Report for BCA Compliance

PROJECT NAME: The University of Sydney – Chau Chak Wing Museum Project

DATE: 30 March 2017

JPW-SK-0088 REV 01 P2  
 AREA OPTION 09  
 LOWER LEVEL 02 PLAN  
 23-12-2016

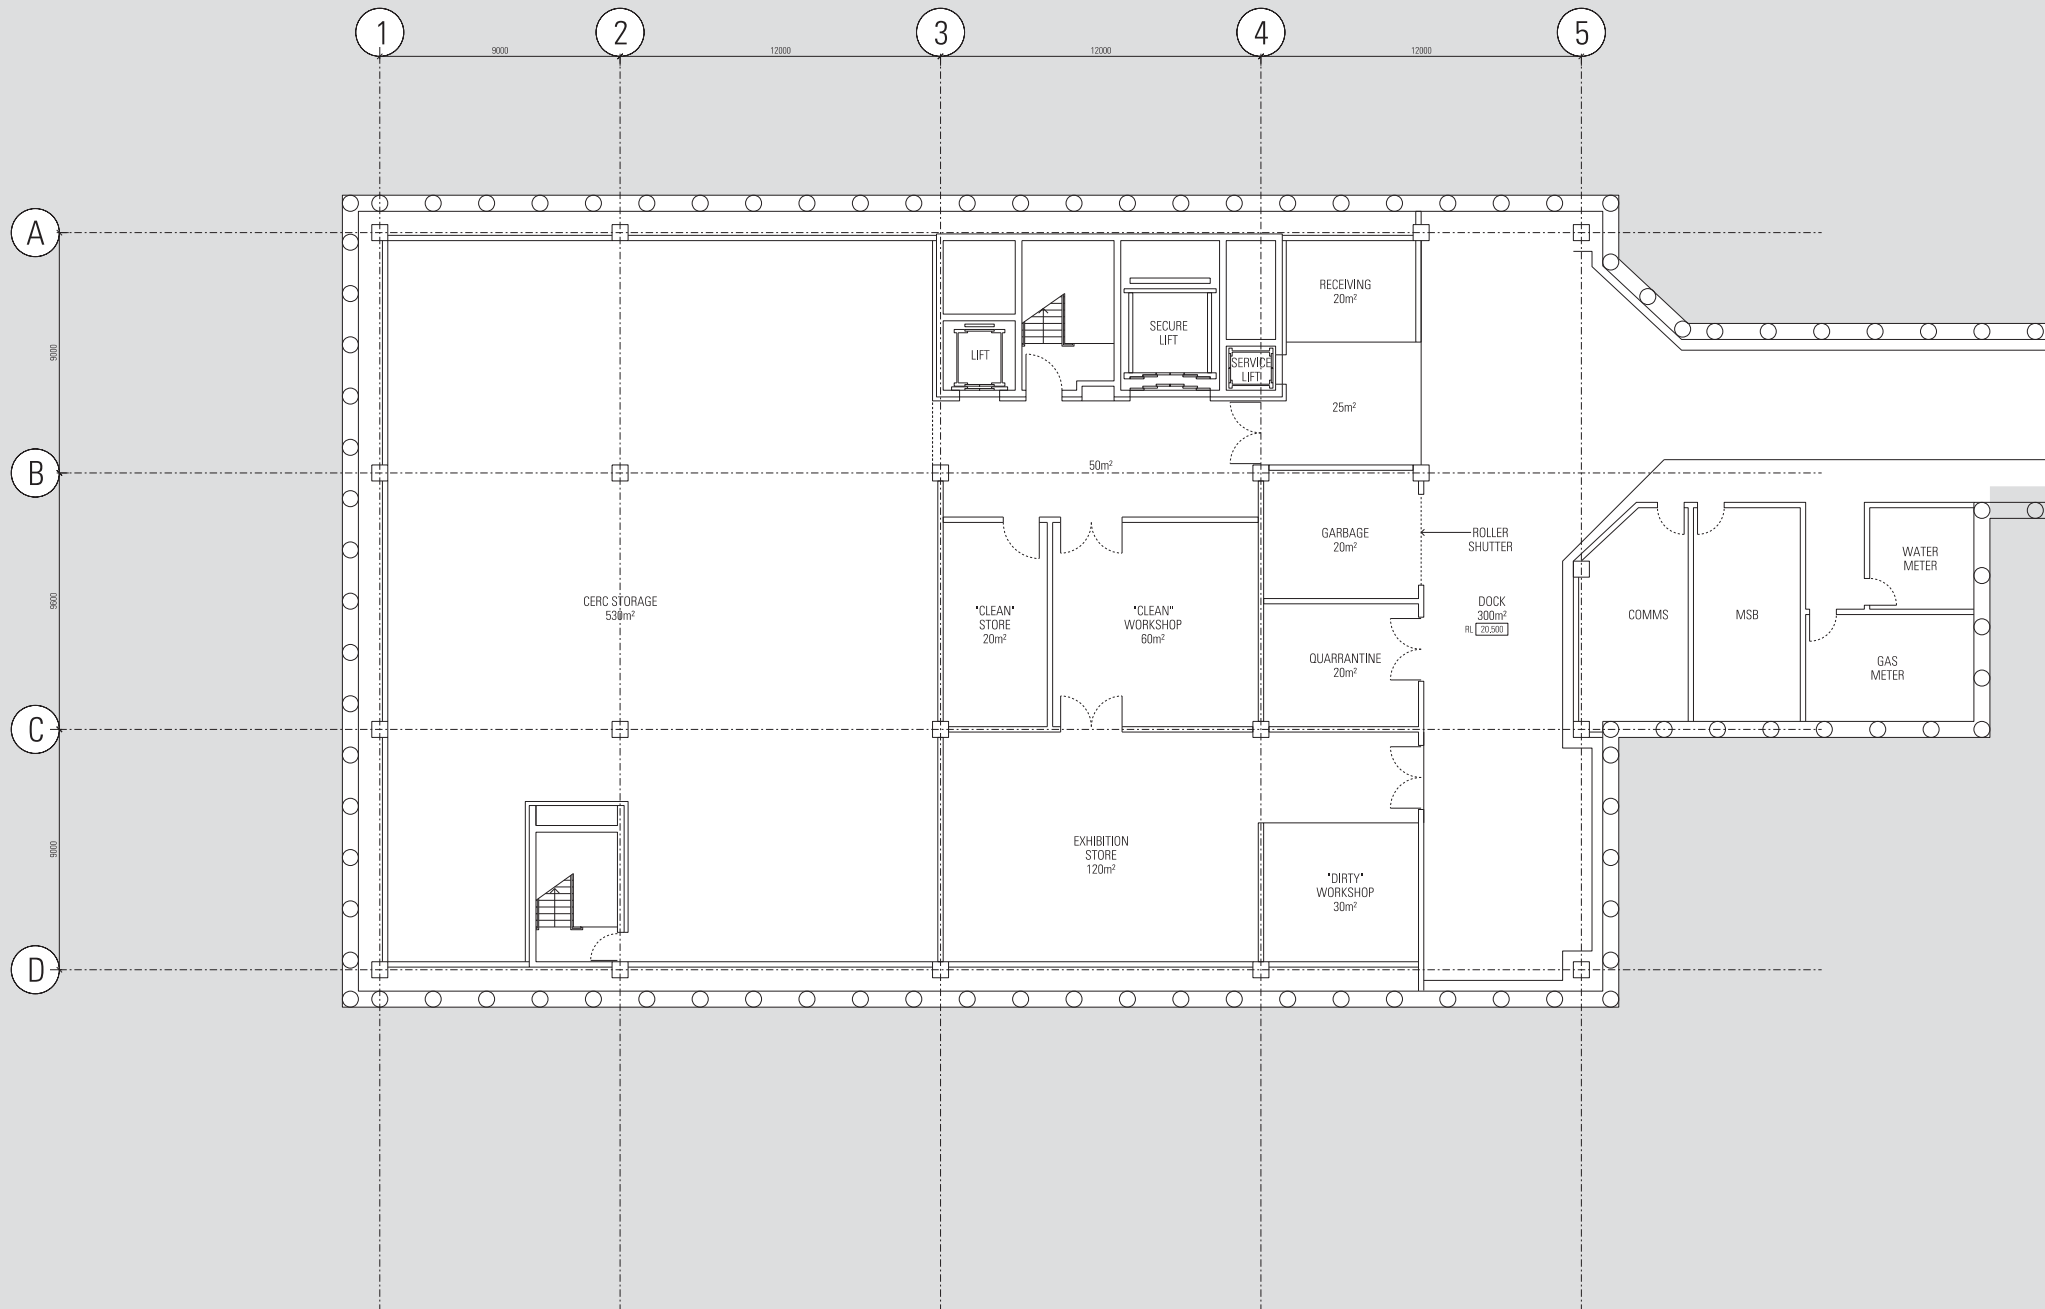
10	Separation of classification on different storeys i.e. the floor that separates the Lower level 02 (collection storage (class 7b)), & Lower Level 01 (Gallery Class 9b) is required to have an FRL of at least 240/240/240 but is proposed to be reduced reduce to FRL120/120/120.	Further comment sought from the Fire Safety Engineer as to the feasibility of Performance Solutions. Post DA Submission.	C2.9	CP2
